**RHS COMMENTS ON REP8-022 UPDATED SOCG
BETWEEN NE AND HE (STILL DATED MARCH 2020)**

100
0 10
Millimetres

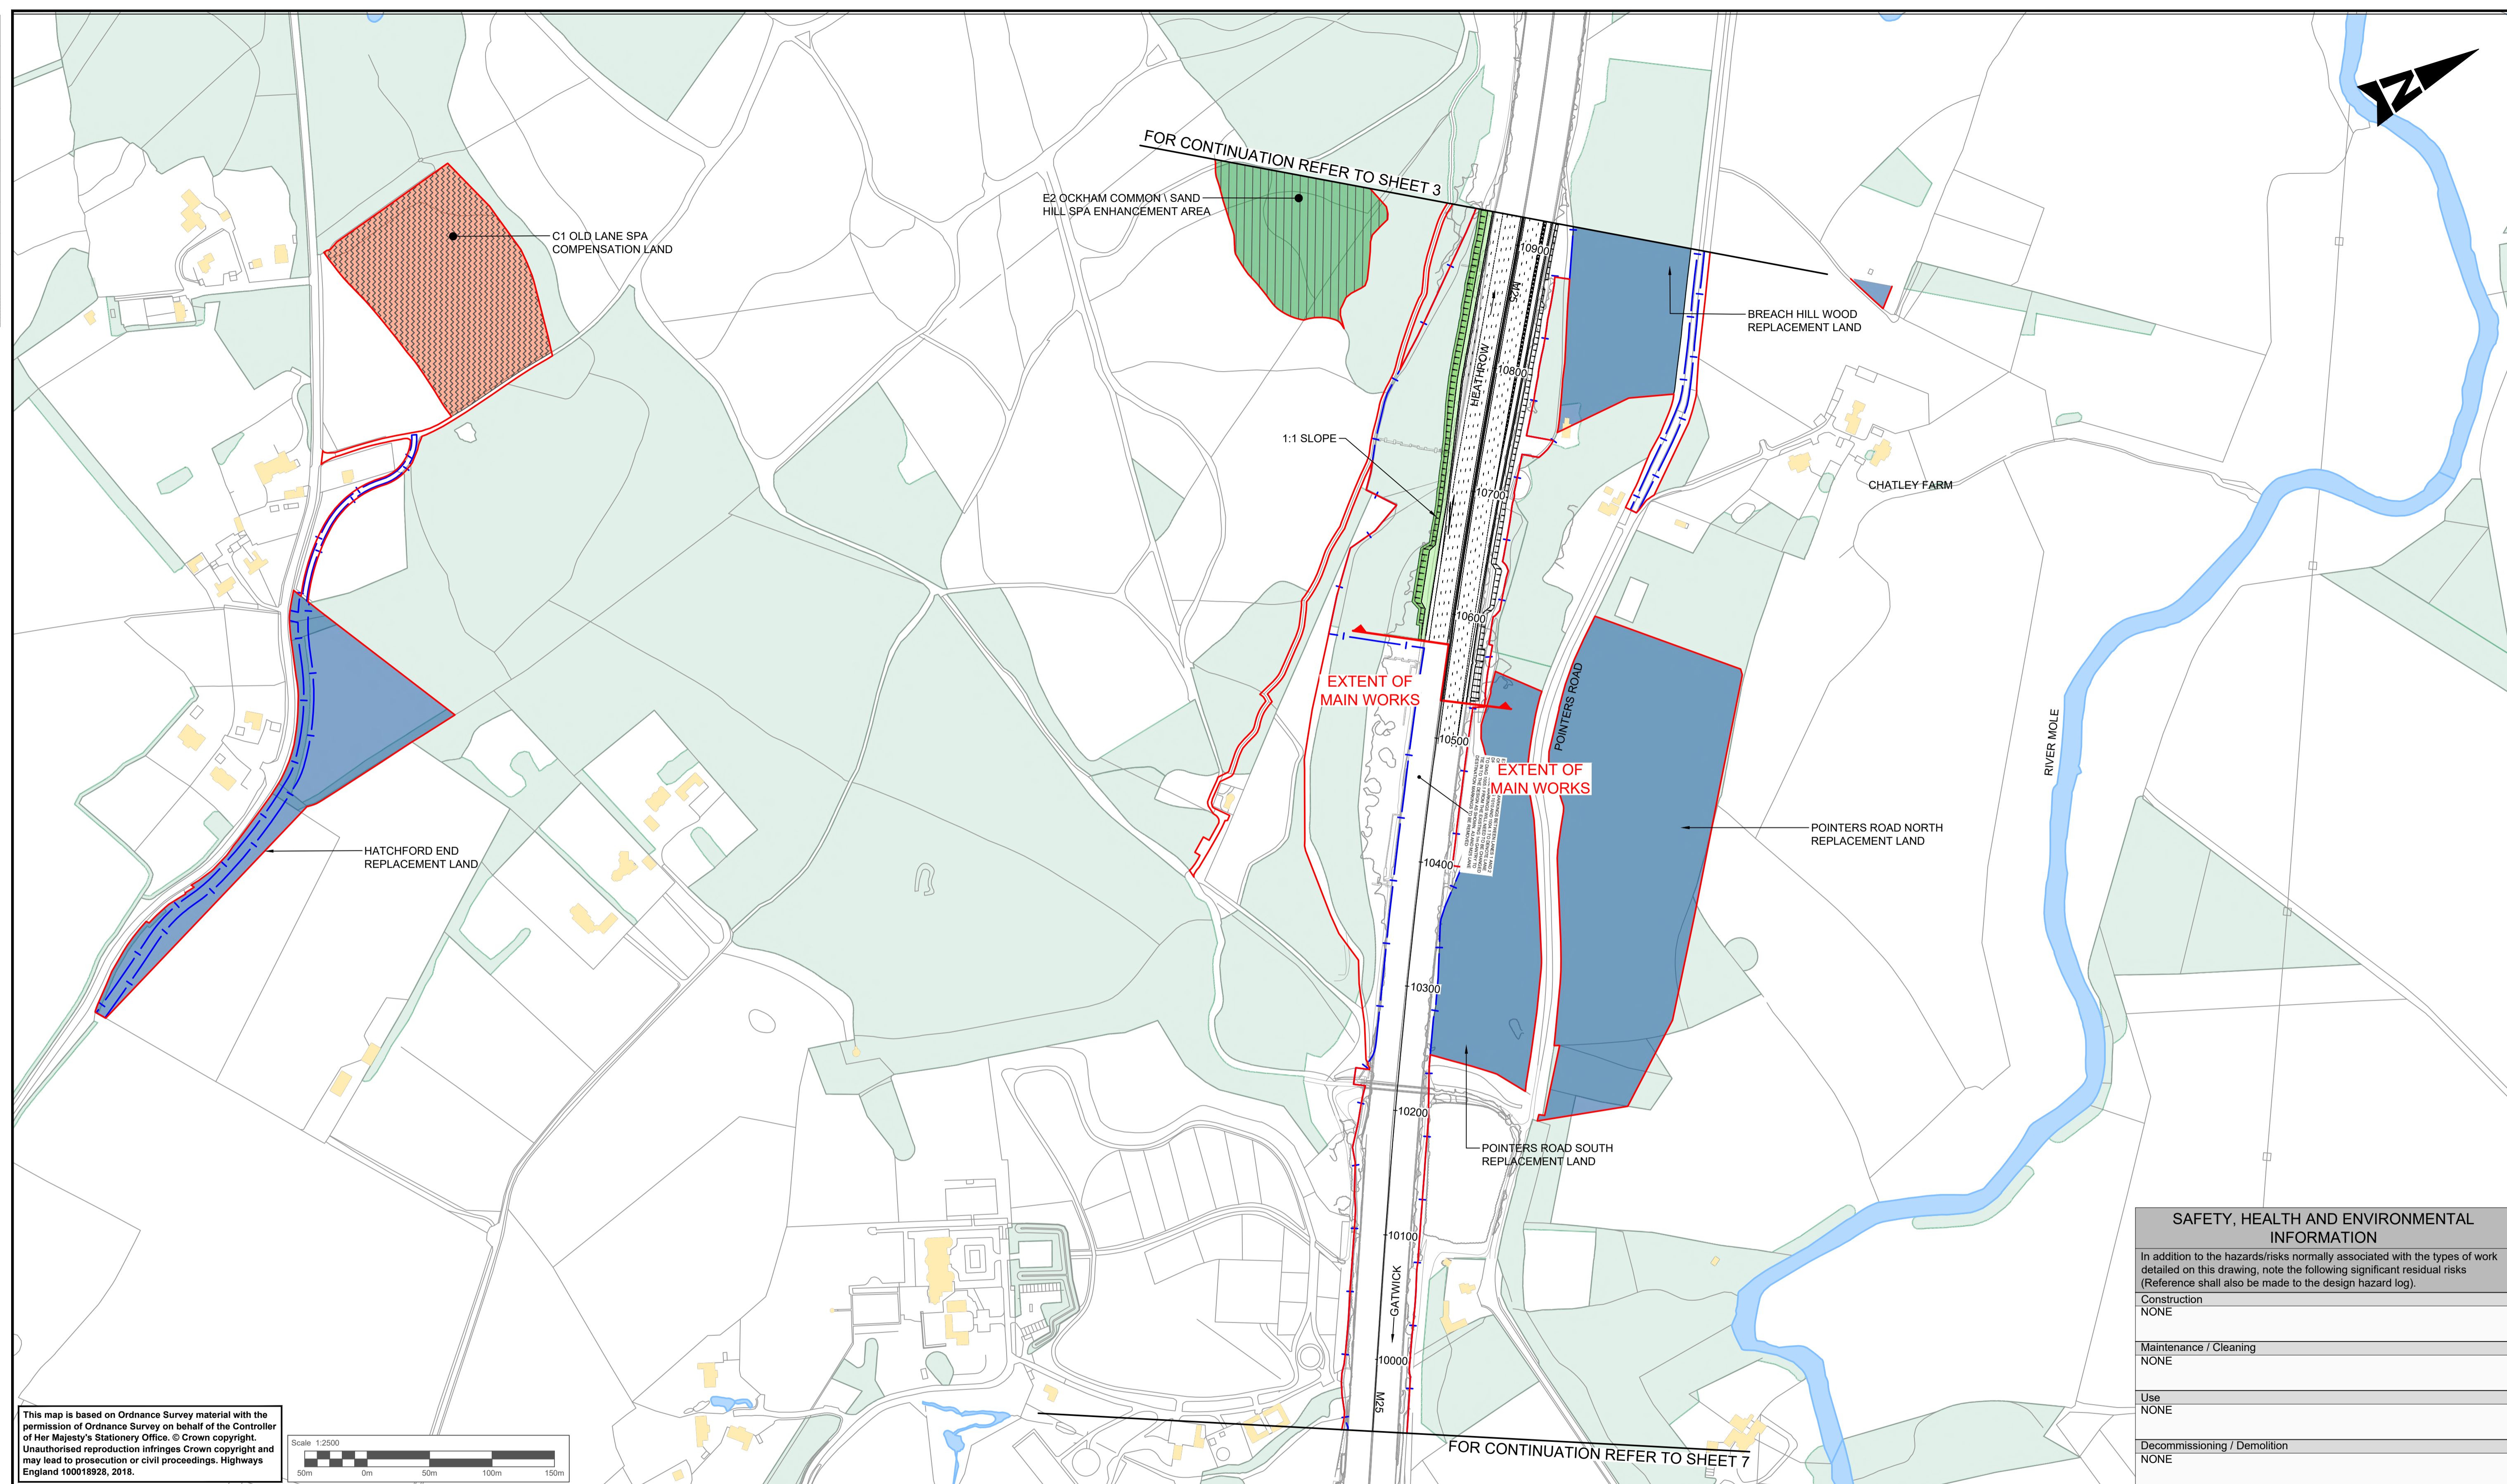
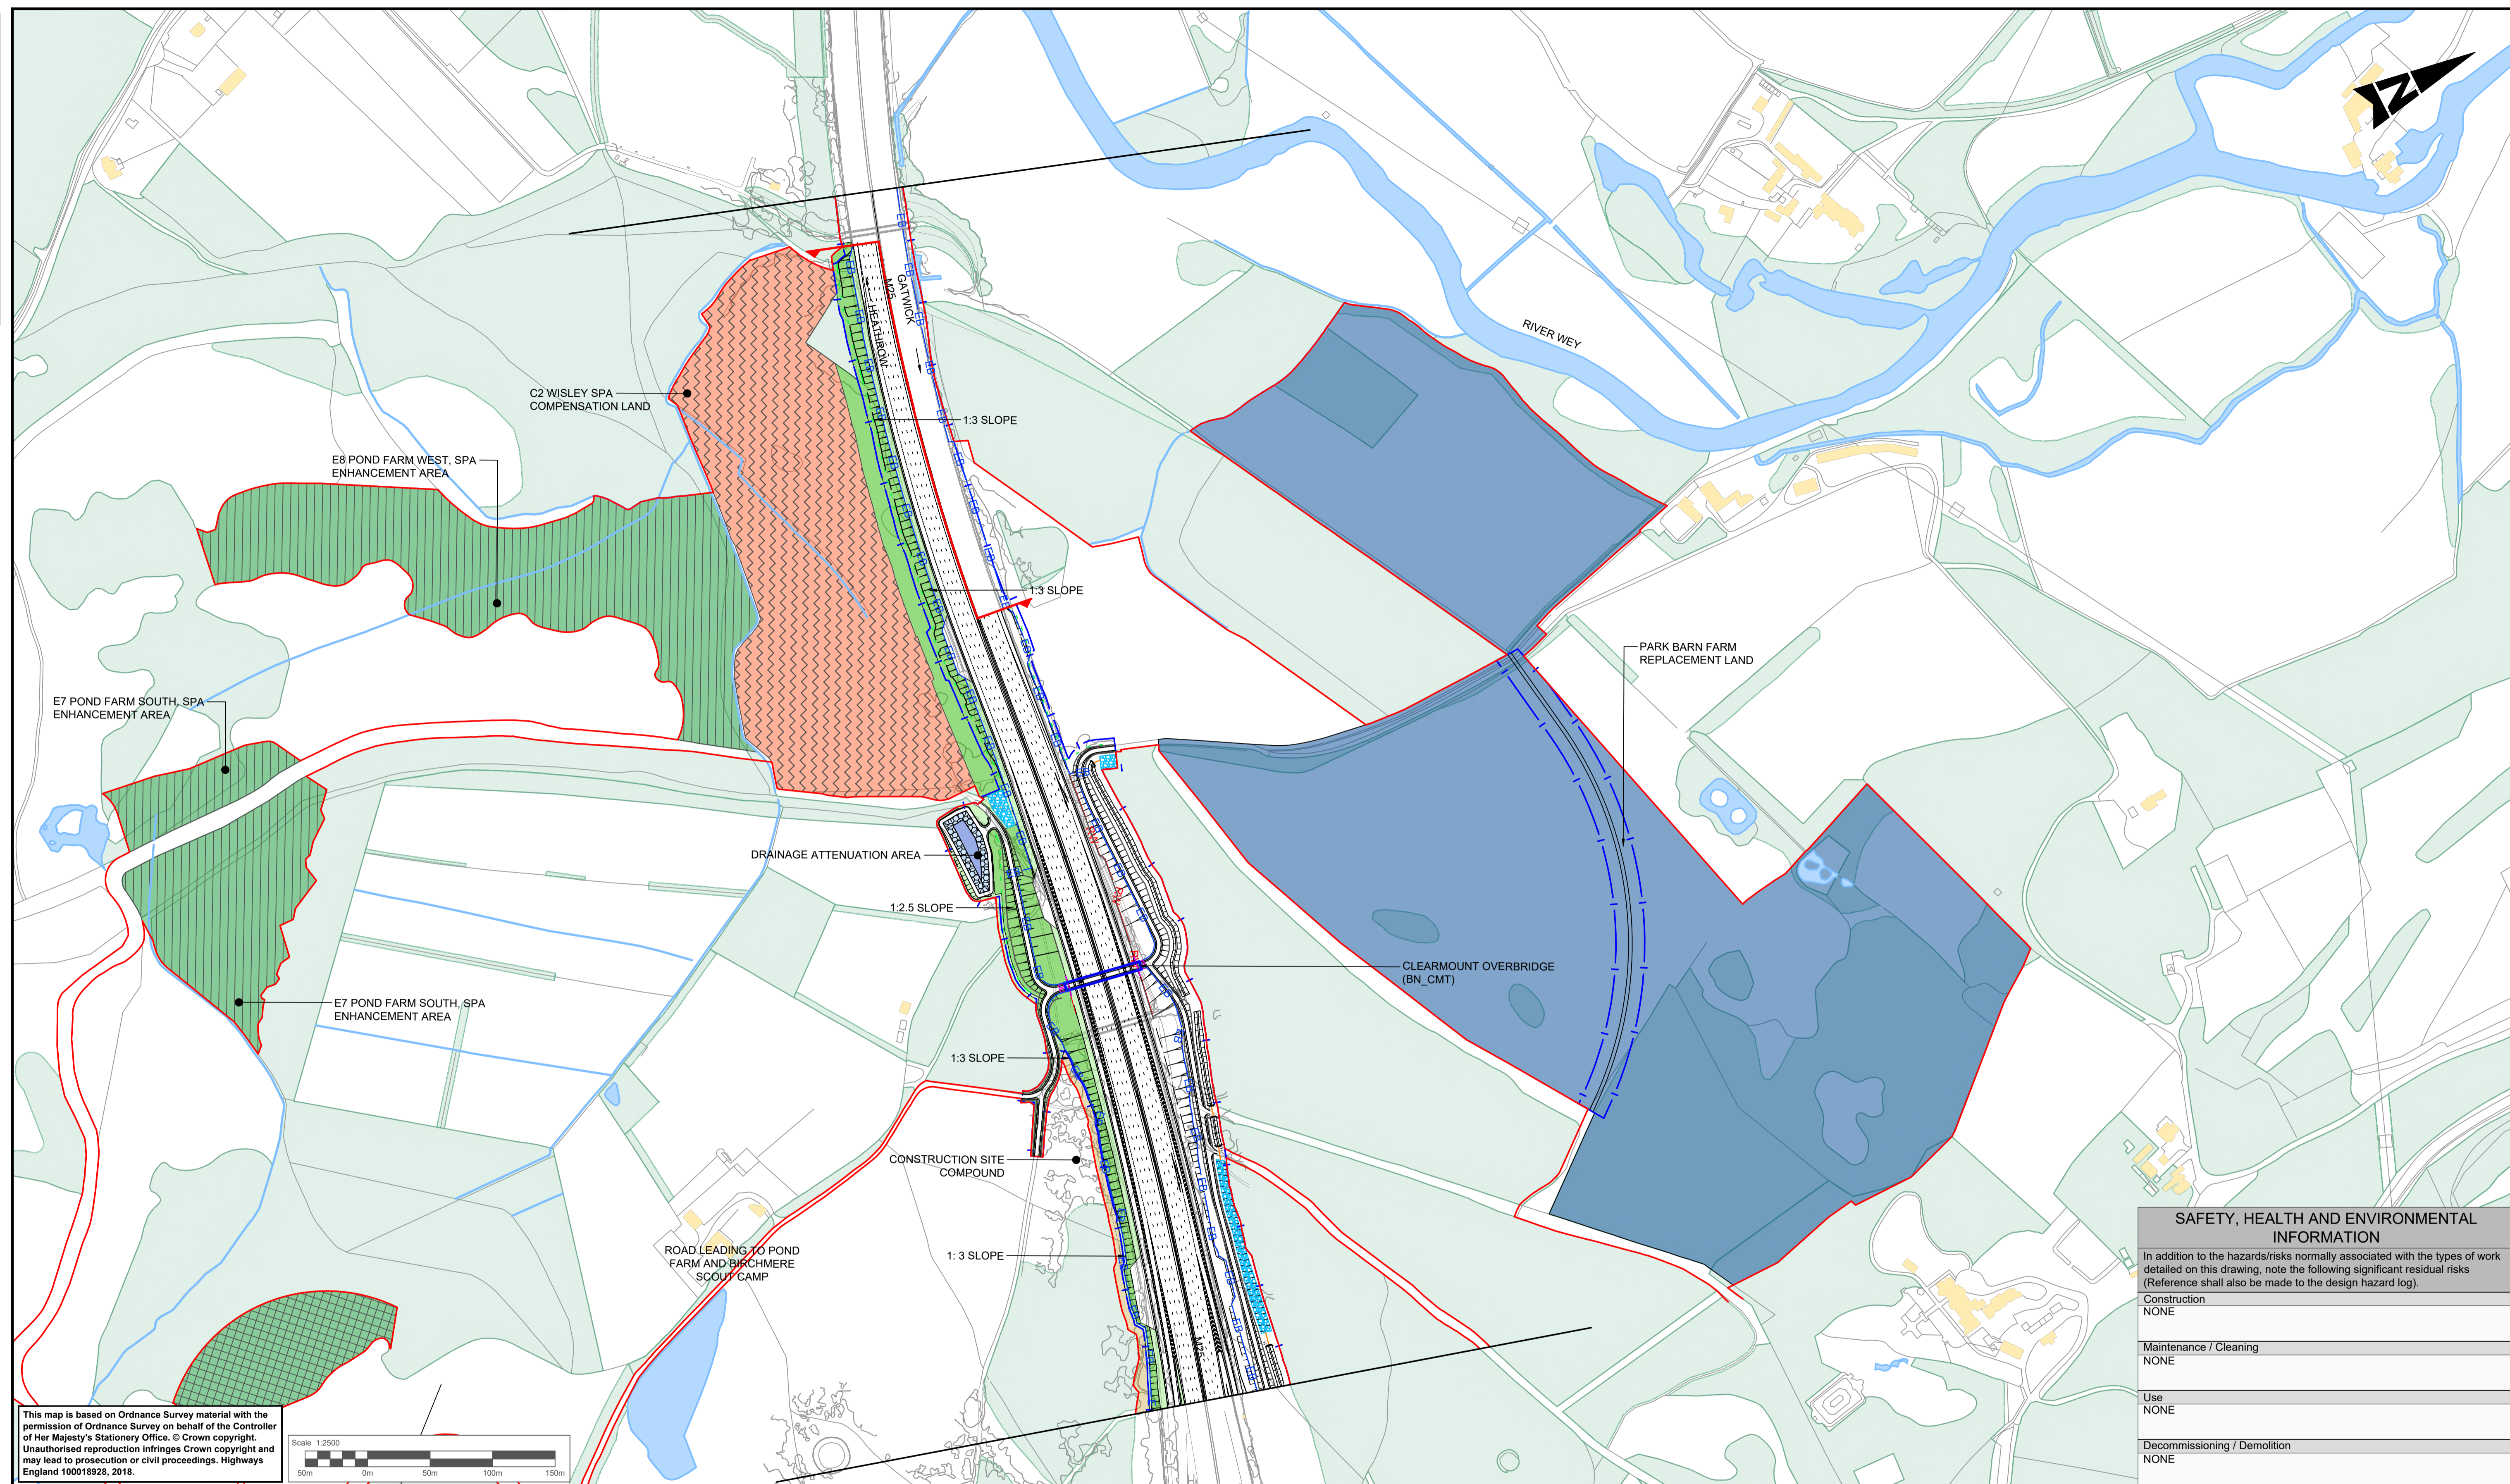
“As explained in 3.2.17 above, Natural England were consulted on and agreed with the suite of compensatory measures. The Suite of compensatory measures will retain the woodland buffer, with the exception of an area of woodland clearance either side of the proposed green bridge (areas E1 and E2 as shown in Figure 13 of the HRA figures [AS-006]). This is in order to maximise the effectiveness of this green bridge, and it has been agreed with Natural England. It is acknowledged that this newly created area of heathland closer to the A3 would be exposed to higher levels of nitrogen deposition than the existing areas of heathland and may require a greater level of management”.

32. The above statement does not accord with the Figure AS-012 rev 2. In Figure AS-012 it is clear that there are large areas of SPA woodland buffer <150m from the roads which will be SPA enhancement areas. These areas will either be thinned out or lost as the land is converted to heathland as set out in HE's REP4-014.
33. Therefore, in fact much larger areas of heathland (than HE is conceding here) will be affected by higher levels of nitrogen deposition since these areas are located within the SPA <150m from the roads. This does indeed throw in doubt the NE / HE assertion that *“the clearance of select areas of the woodland buffer as part of the suite of compensatory measures does not conflict with NE's conservation objectives for the TBH SPA”* (3.2.18 SoCG).
34. HE and NE then state:

“In addition, the SPA enhancement area E5 also requires some clearance of the woodland buffer between the heathland and the A3. However, there will still be a retained belt of approximately 75m of woodland at this location separating the heathland from the A3 and this belt of woodland will continue to provide a buffer function.”
35. RHS has measured this area from Figure AS-012 rev 2 and makes it 50m, not 75m. Again this E5 area of proposed compensatory heathland will also be affected by higher levels of nitrogen deposition since it is located within the SPA <150m from the roads.
36. RHS refers to its REP8-054, paragraphs 96-108, where RHS explains why, given the absence of adequate air quality data provided by HE for the SPA zone <150m from the roads, the requirement for technical feasibility of the HE compensatory measures is not met.
37. HE and NE then state:
